Amendment application – Butlins Resort, Bognor Regis

Planning Portal ref. PP-08688168

Original application ref. BR/240/16/PL

The applicants chose the latter course of action. It is therefore necessary to substitute drawing PI 10A with PI 10B to affect this minor change, and in doing so this means it is necessary to vary the wording of both Condition 2 and Condition 13.

PWP Architects Ltd 81 South Street, Havant, Hampshire PO9 1BZ  
t: 02532 262694 f: 02532 481152  
e: design@pwp-architects.com  
w: www.pwp-architects.com  
job: 5128 P110 rev: B

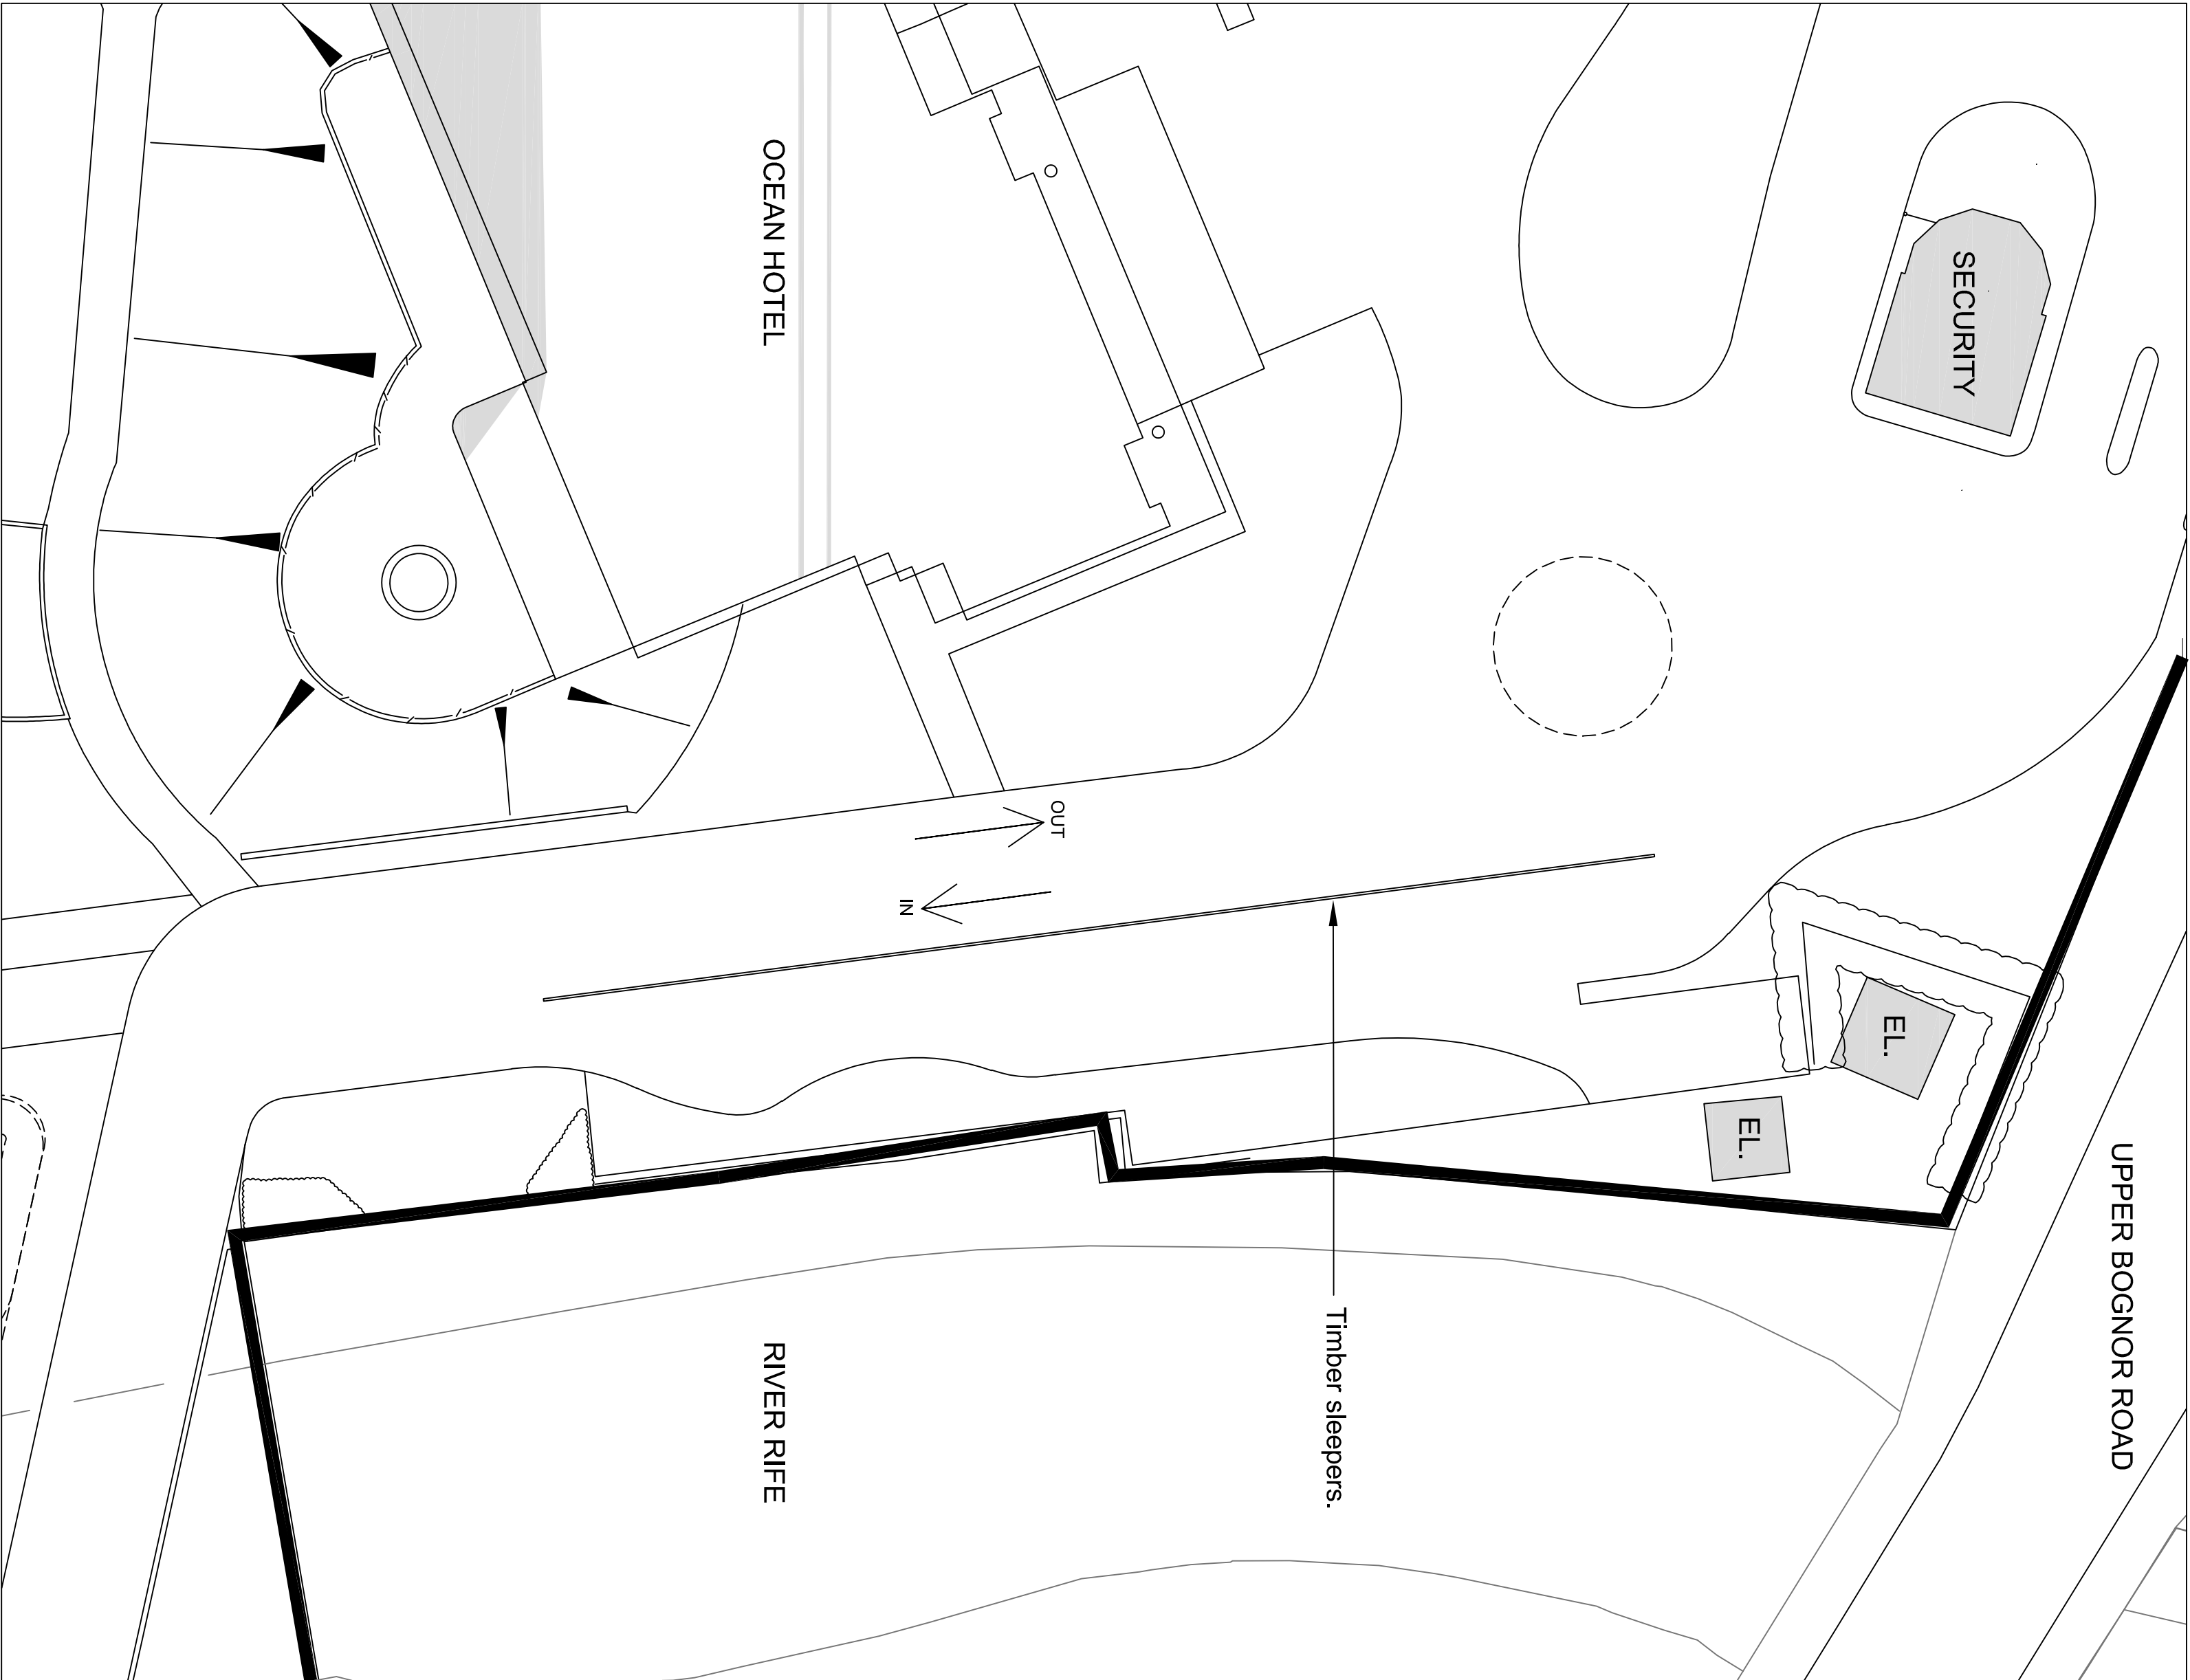
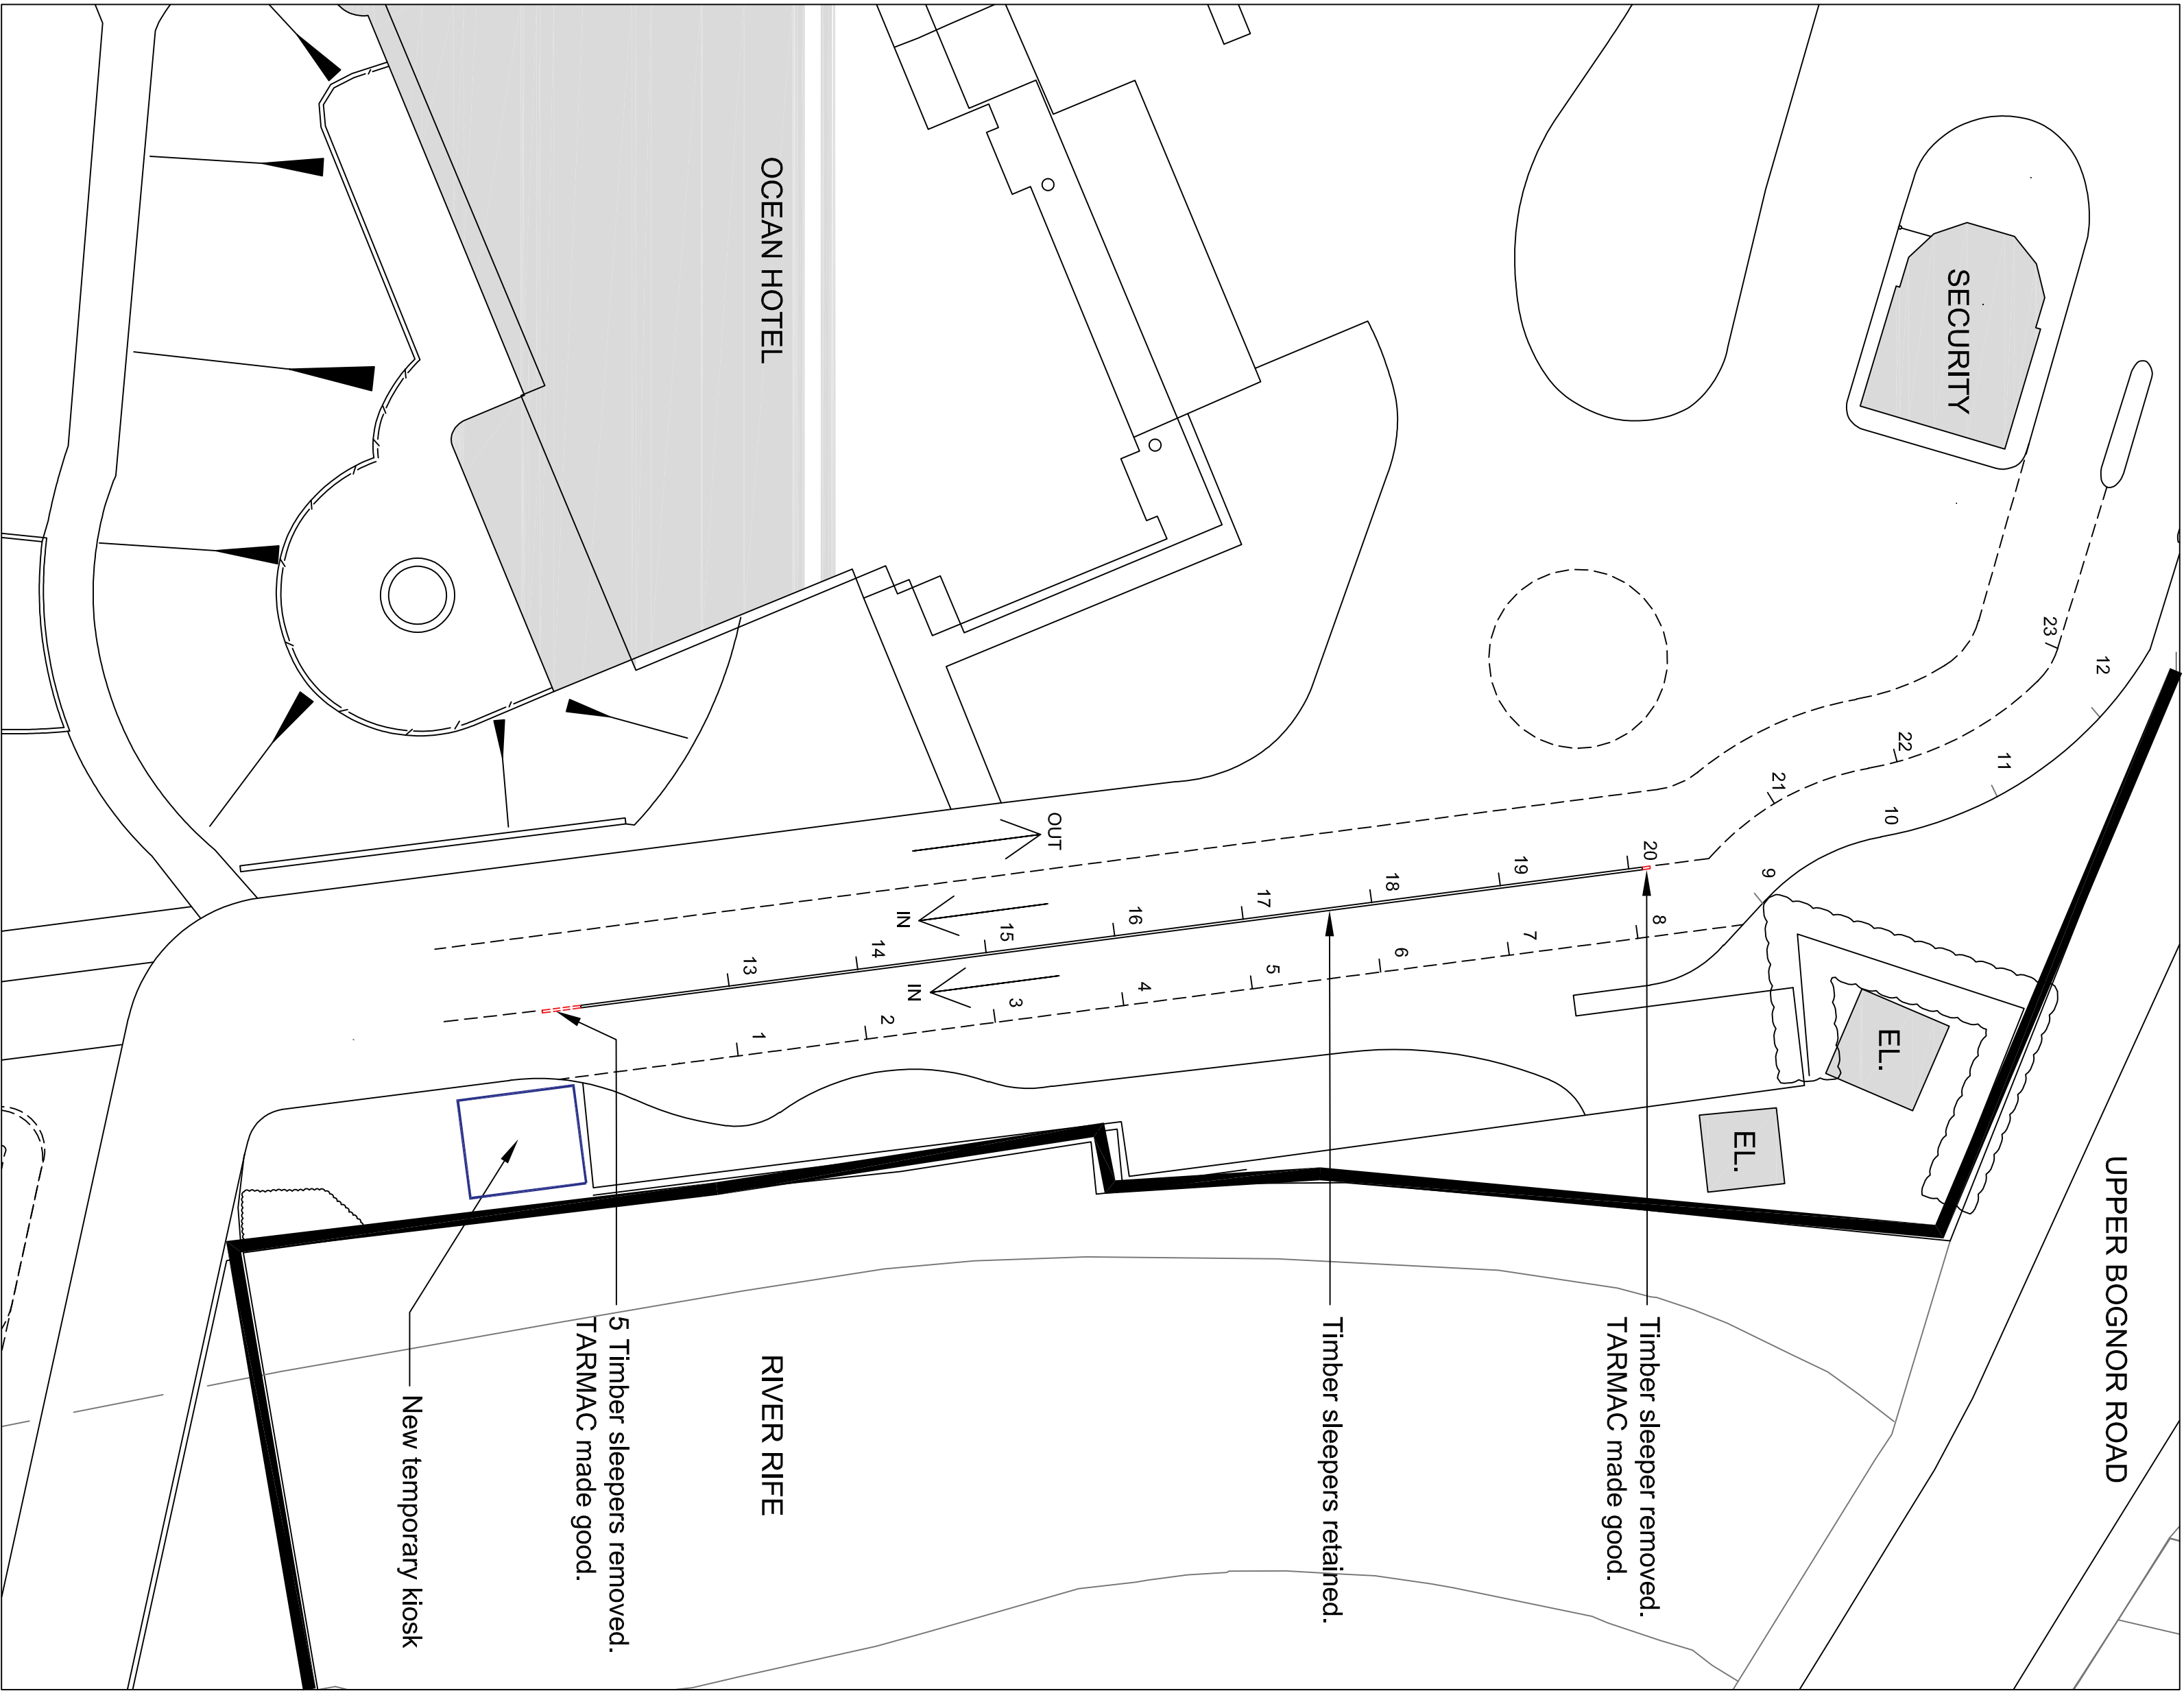
However, the guest check-in area and vehicle access point at the main gate has been laid out in a different arrangement to that shown on the approved drawing. Therefore, it is either necessary to rationalise what has been laid out at the site versus the approved drawing so that there is no longer any breach of condition, or to revise the condition requirement.

The Management Plan provides a mechanism to control and manage guest check-in at the main entrance, including an updated layout of vehicle lanes and a new location for the staff kiosk.

This holding area includes a kiosk for staff for storage or wet weather shelter. The appearance of this "gatehouse for guest reception" (as referred to in the description of development on the original consent) has been updated to reflect the new hand-held check-in system and more mobile staff. The location has changed on the plan, and its appearance has changed on the relevant drawing.

The reason for this deletion is that the design of the kiosk has changed and has been built, and this is shown on 5128 P110 rev B.

- 5128 P110 rev B Entrance Site Plan;

13	Prior to first occupation of the approved development, the permanent access to the site shall be constructed in accordance with the approved site plan drawing number 5128 P110 Rev A The permanent access to the site shall be retained in situ in accordance with the approved site plan drawing number 5128 P110 Rev B and shall be operated only in accordance with the Management Plan hereby approved.
